Planning Application Ref: FP/199/17/T

Location : 6 Ceres Place, Felpham

Description of works: Reduce crown of two Pines by 3m to 5m and felling one Sycamore

Garden of 6 Ceres Place.

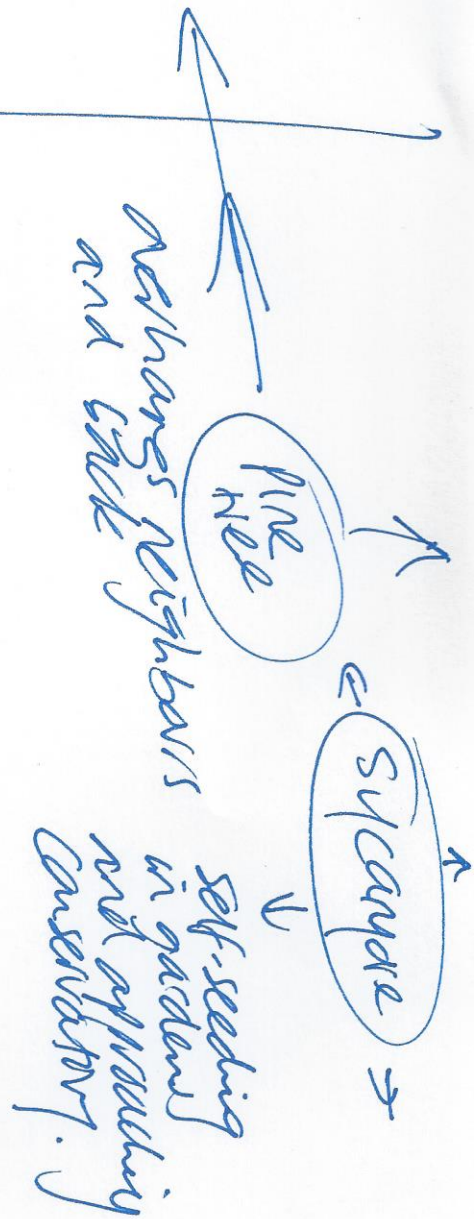
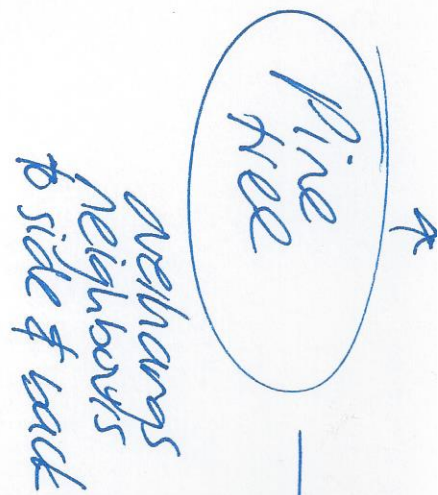
- To reduce the top 3m to 5m from these two trees would completely remove all live growth and this would kill the trees as this type of conifer cannot regenerate live growth from trunks and bare branches.

- A self-sown tree of ragged form and low overall amenity value.

- The reduction of the Pine trees is totally unacceptable.
- The felling of the Sycamore is acceptable.

- I recommend **APPROVAL** for the removal of the Sycamore.
- I recommend **REFUSAL** for the pruning of the Pines.
